Erection of 4 No. dwellings, 1 No. detached garage, parking & alterations to existing access & driveway (resubmission following BR/200/16/PL).

Land to rear of 41 - 47 Pevensey Road Bognor Regis

Thank you for your internet representation made on 11th October 2017 which has been recorded as '**an objection**' with the comments as follows:

Drawing title: Tree Protection Plan

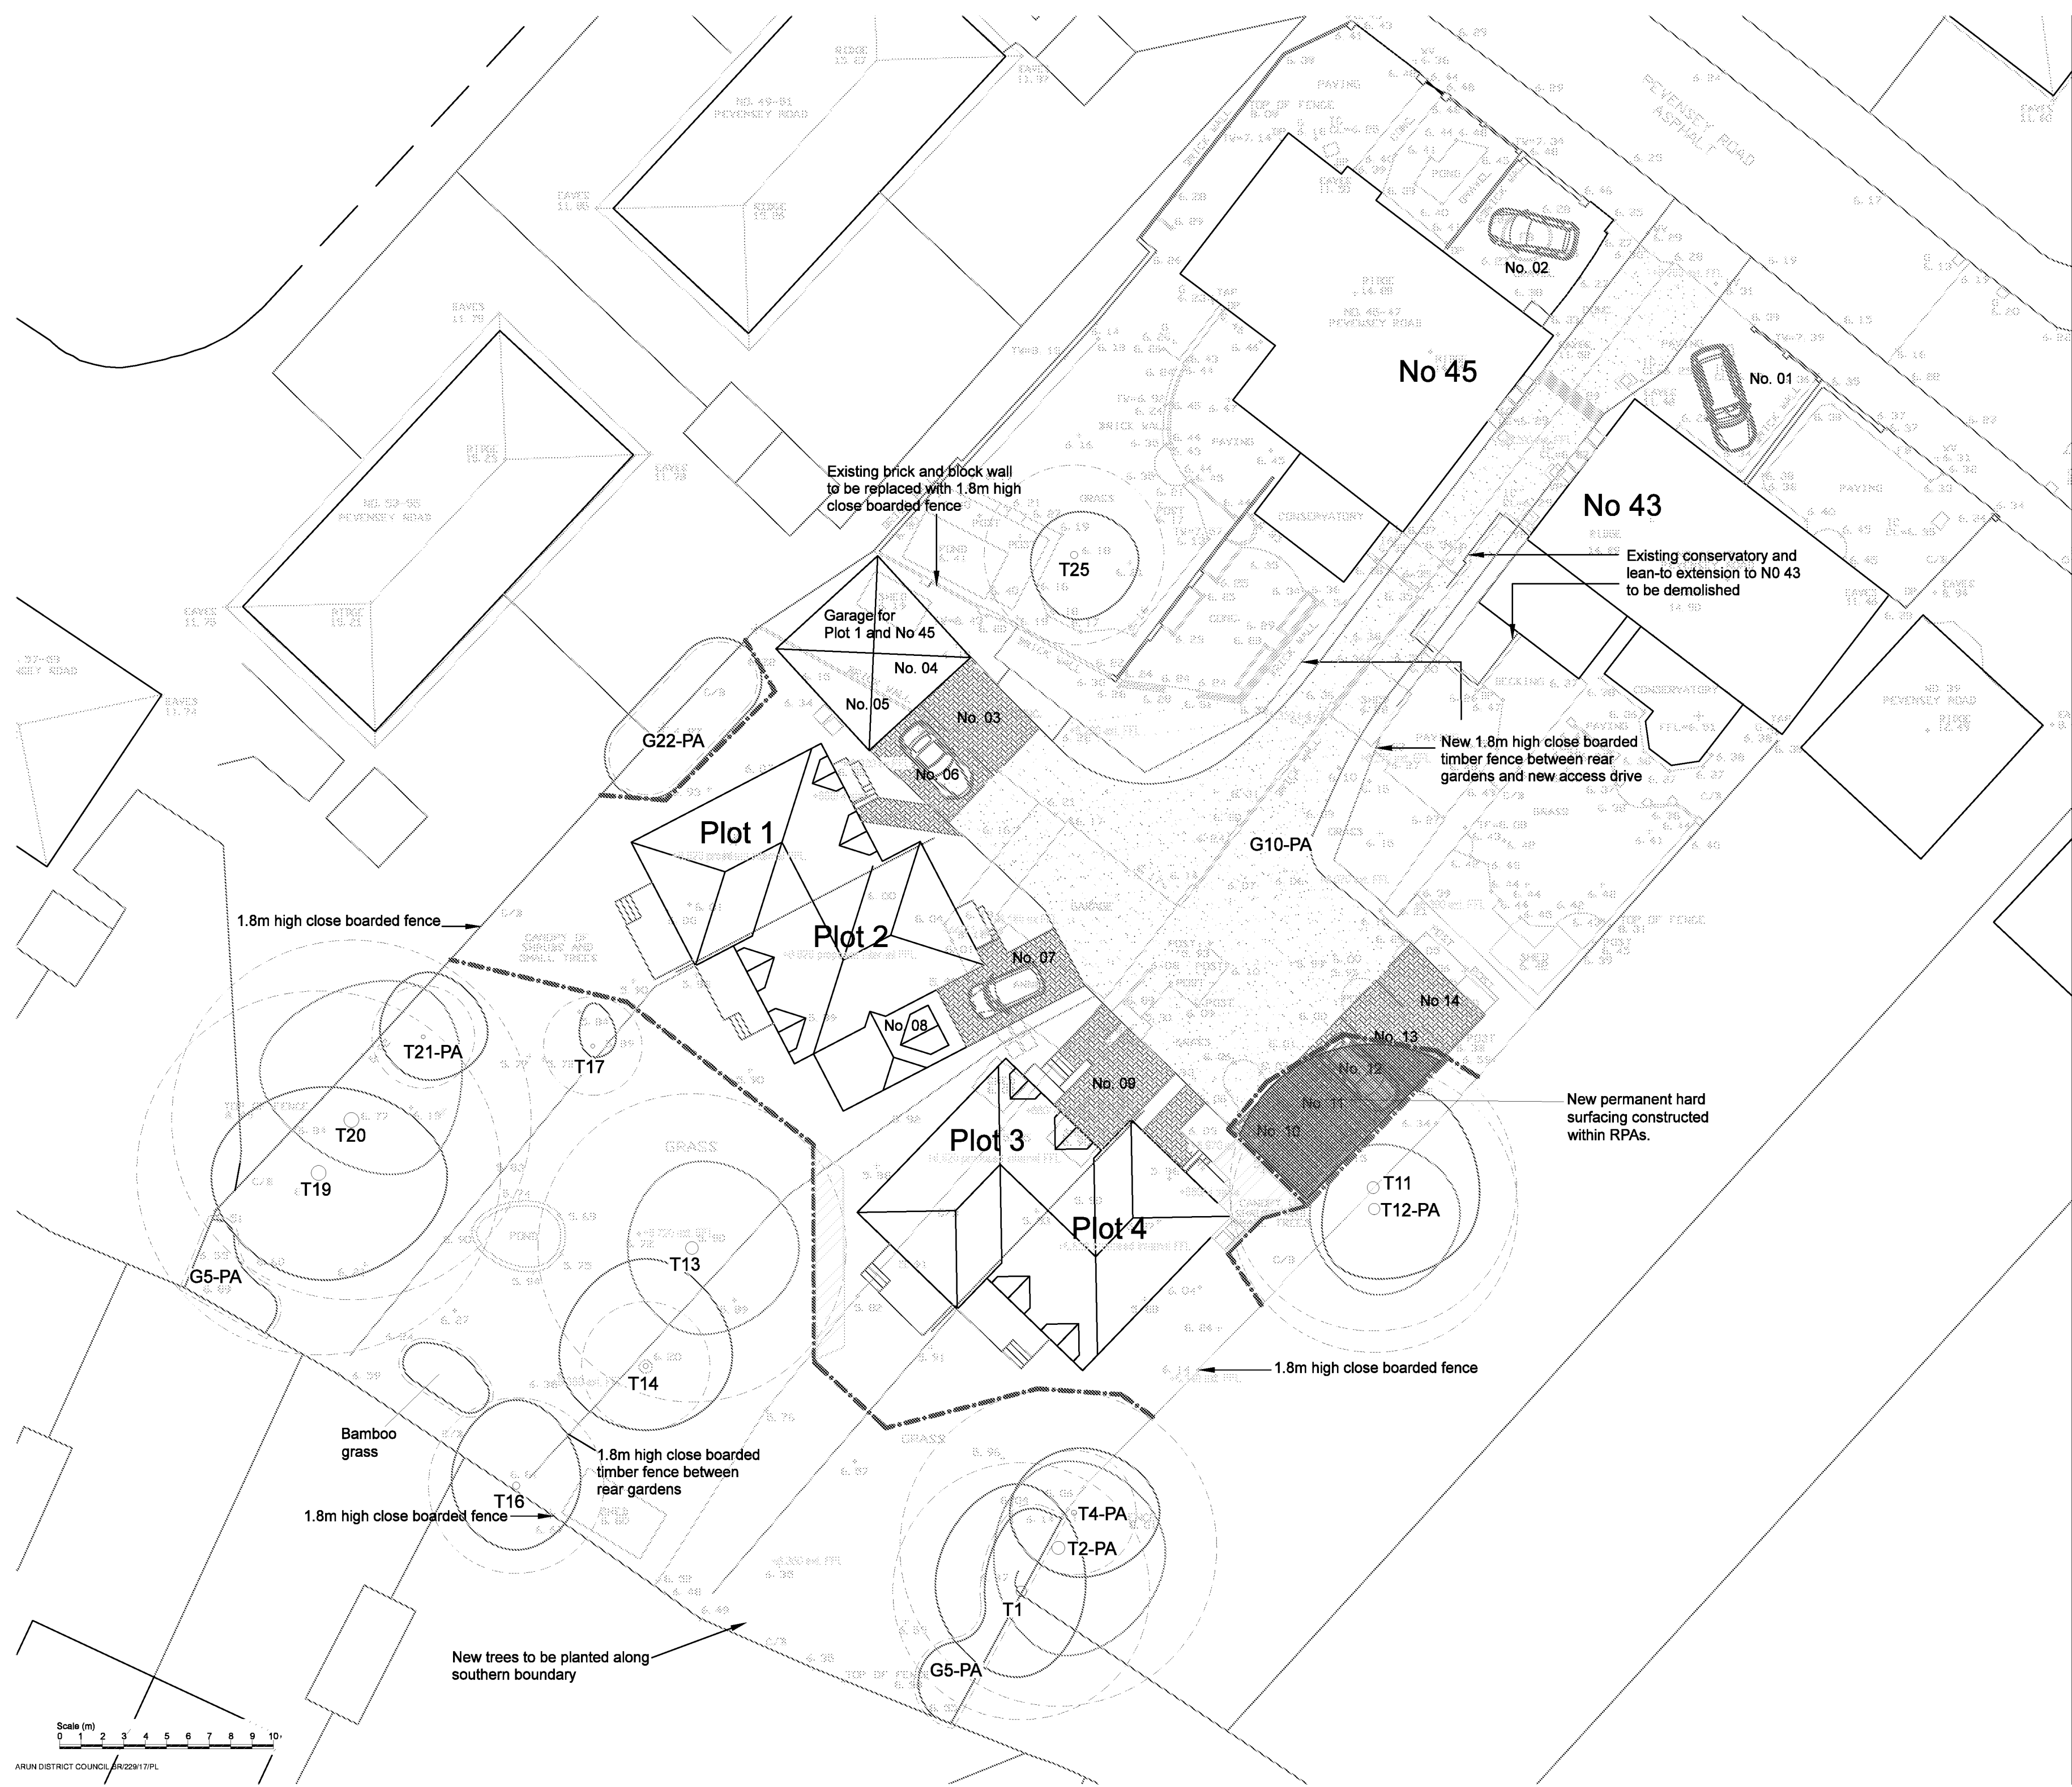
2. I have 2 extremely large protected trees in my garden right along the boundary fence that runs between number 43 and my garden, if foundations for a house and car parking spaces are going to be put on top of the tree roots of these two trees they will be damaged and will then subsequently have to be destroyed. Why should I have to lose 2 beautiful trees that are in MY garden for the sake of 4 houses! Building over these roots will kill the trees and that's a fact. These trees are protected for a reason and the council should make sure they stay protected.
